**Lancashire
Constabulary**

Rachel Emmett
Architectural Liaison Office
Lancashire Constabulary
Saunders Lane
Hutton
Preston
Lancashire
PR4 5SB
01772 412 892
07432629040

18th July 2012

Planning ref 3/2012/0578

Site Layout

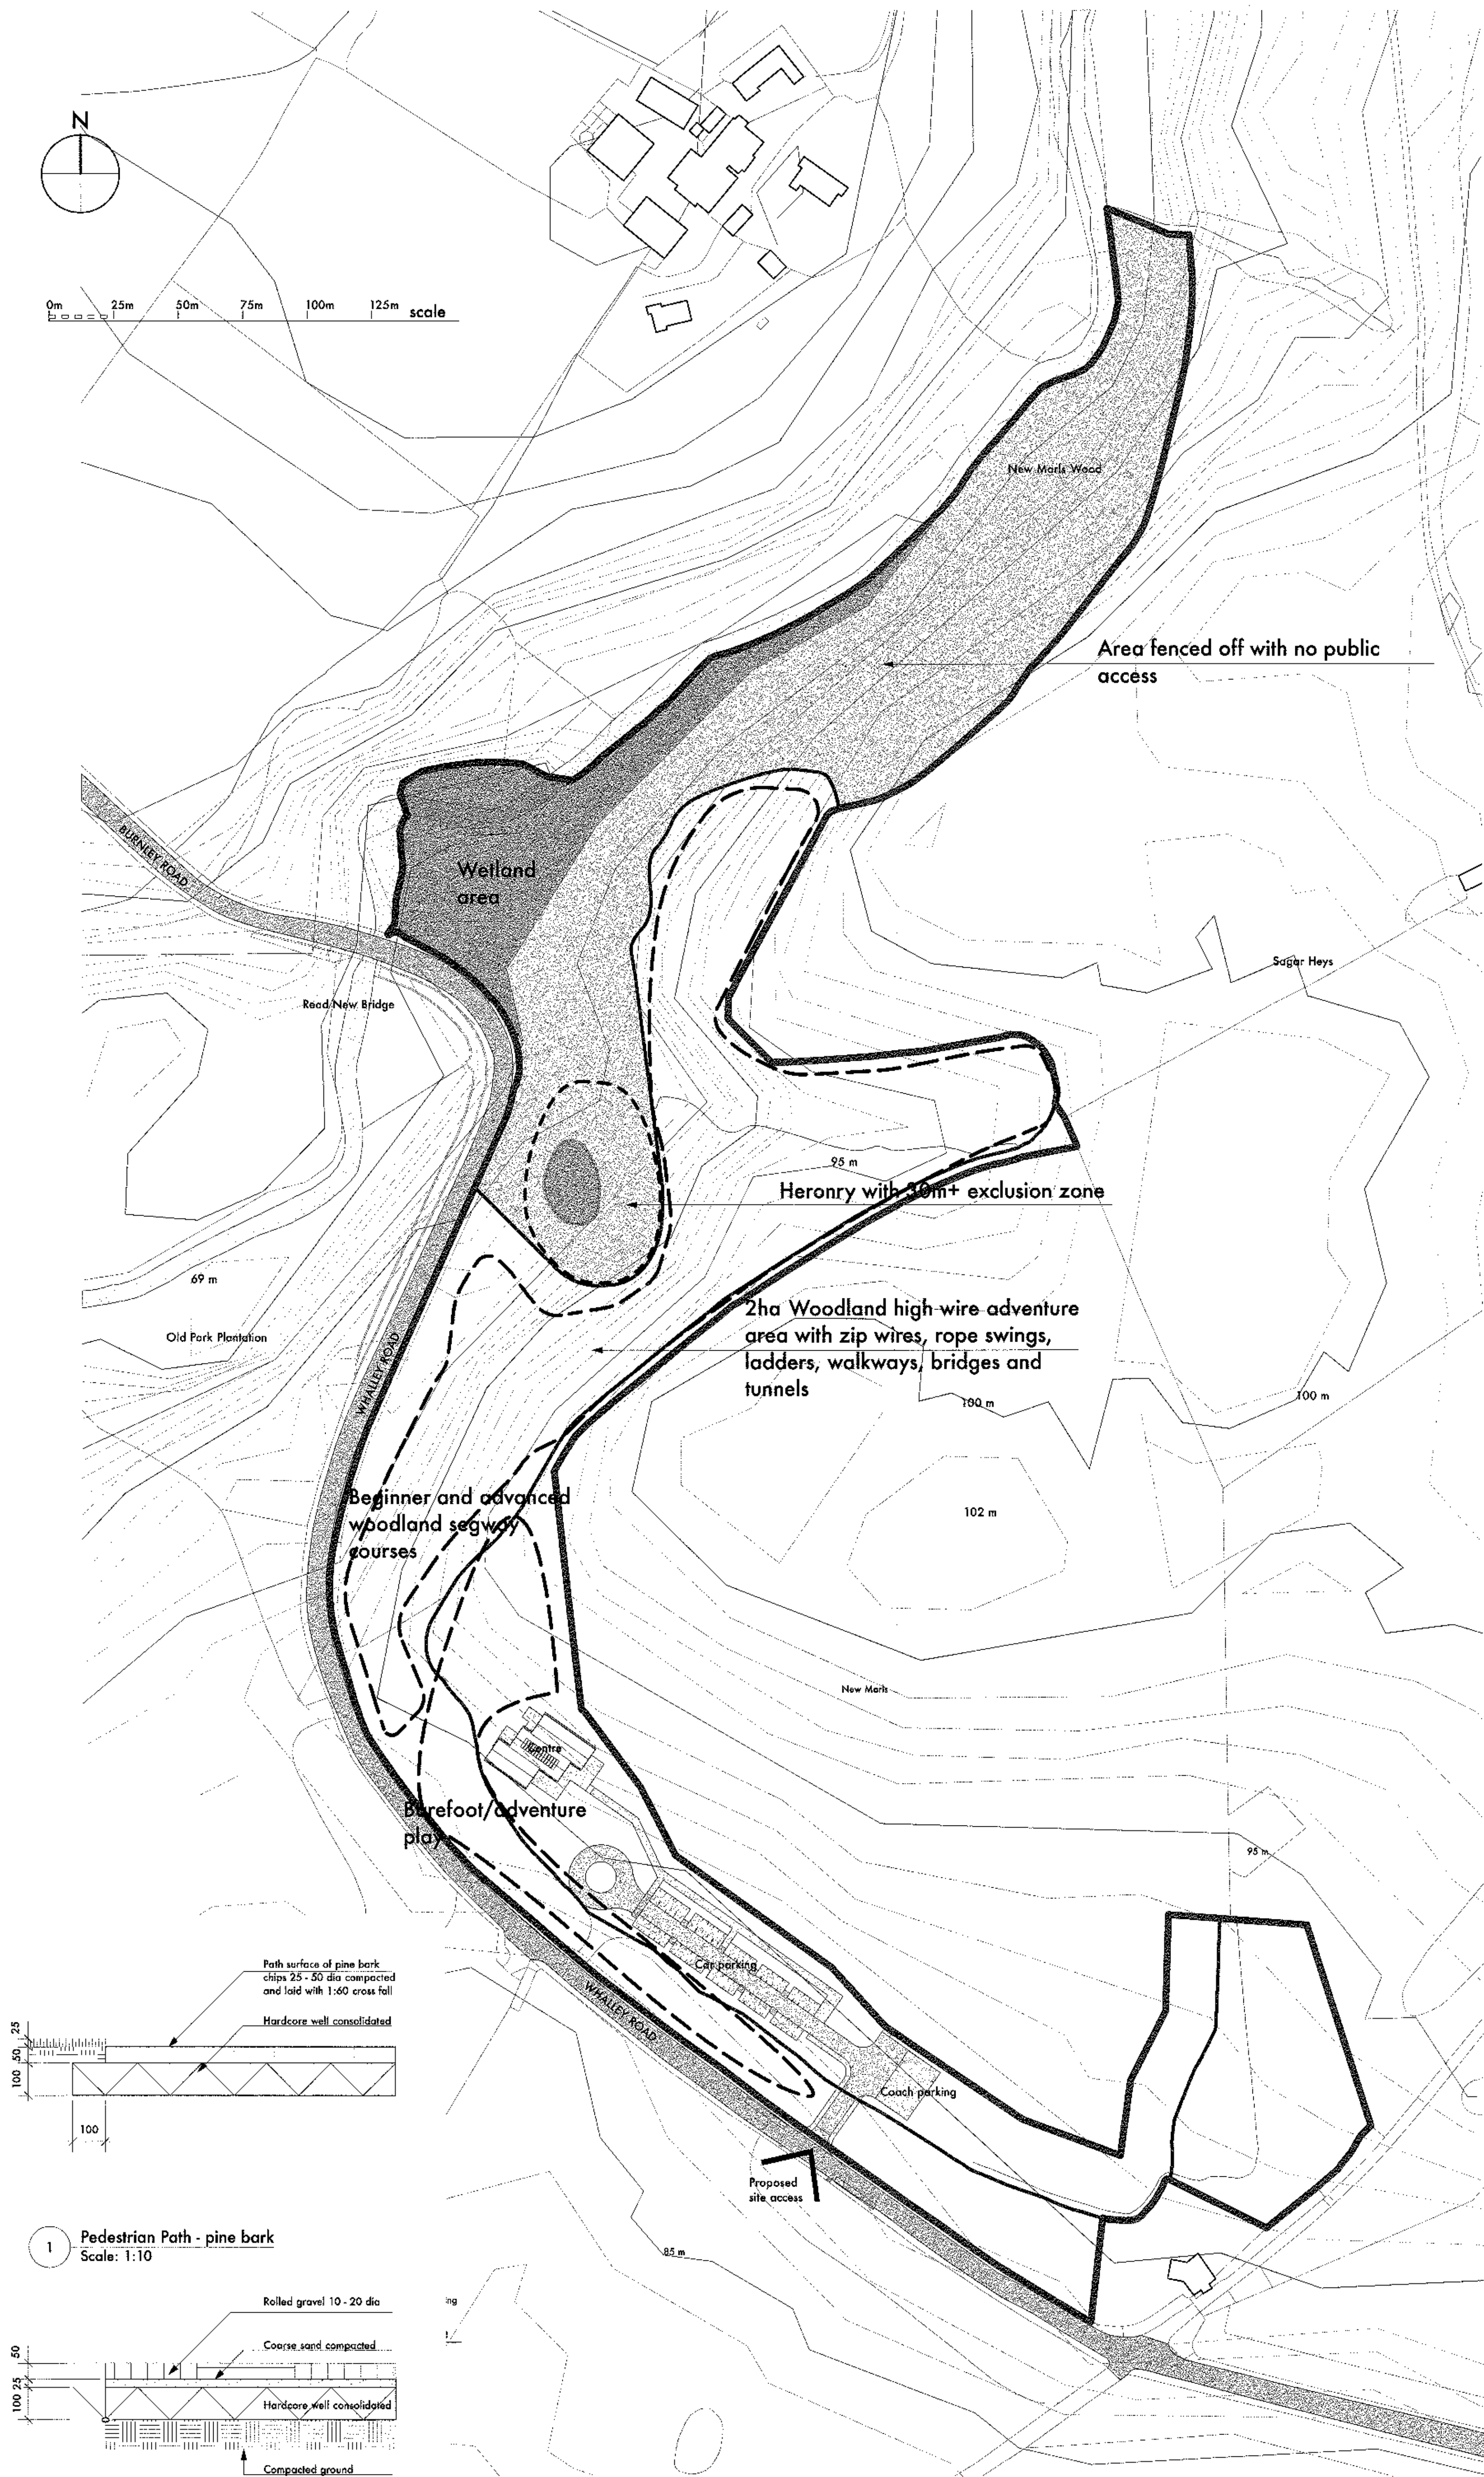
- Crime within this area is generally low however to balance this it is a very rural area with few residential and commercial premises. The most frequent types of crime within this area are burglary and car crime. Therefore security of the buildings on this site and car parking are the areas that should be concentrated on.
- The covered area of the accommodation units gives me some concern as it could be used as an area for youths to gather in out of business hours – this could lead to anti-social behaviour, graffiti and criminal damage and burglary over time. Consider closing this area off out of hours with lockable gates or similar that cannot be climbed over.

- I would advise that a substantial and correctly installed vehicle barrier be installed at the car park entrance to prevent access out of hours. This would prevent the car park being used as a gathering/meeting place at night by teenagers with cars who may create noise nuisance/litter/graffiti etc. I feel the installation of a barrier would reduce the need for the accommodation area to be gated off.

Proposed Elevations

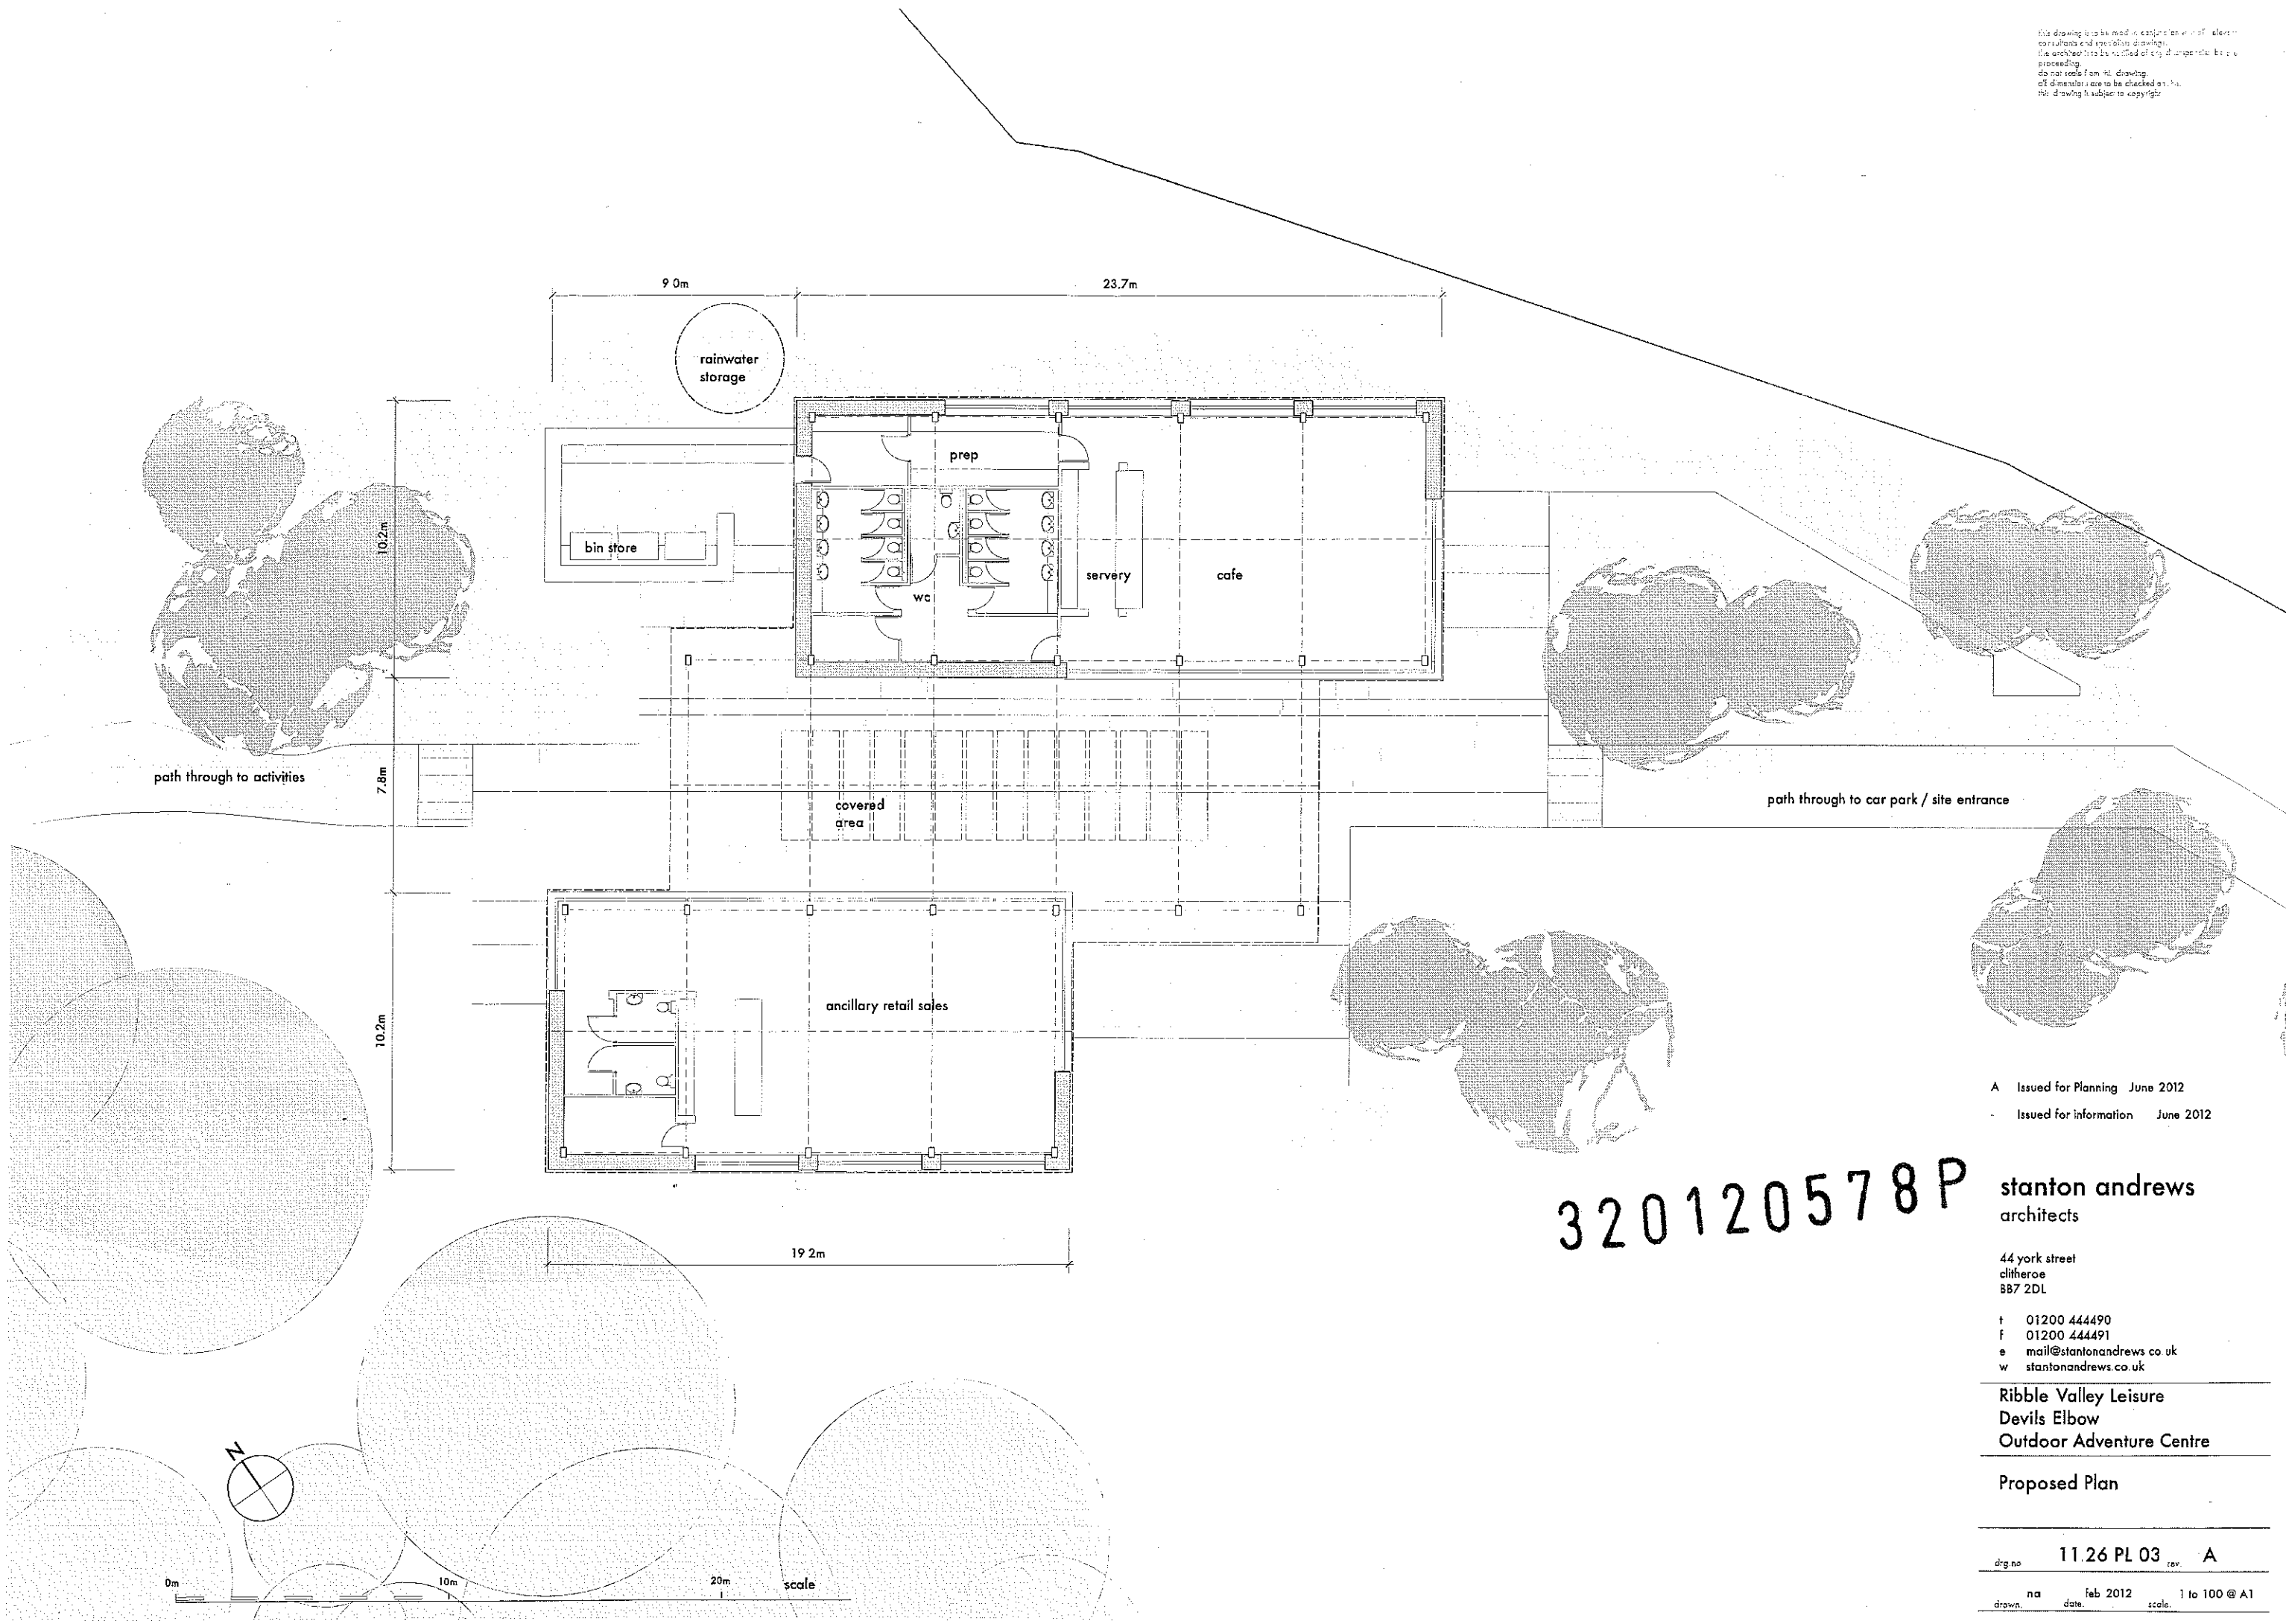
- The design of the accommodation being built into the hillside could allow intruder access onto the roof. I acknowledge the design has a steeper roof than the norm however as an added measure I would advise using thorny planting along the perimeter of the buildings. Common Gorse and Berberis would be options to consider as they would be in keeping with the environment and provide berries to attract birds.
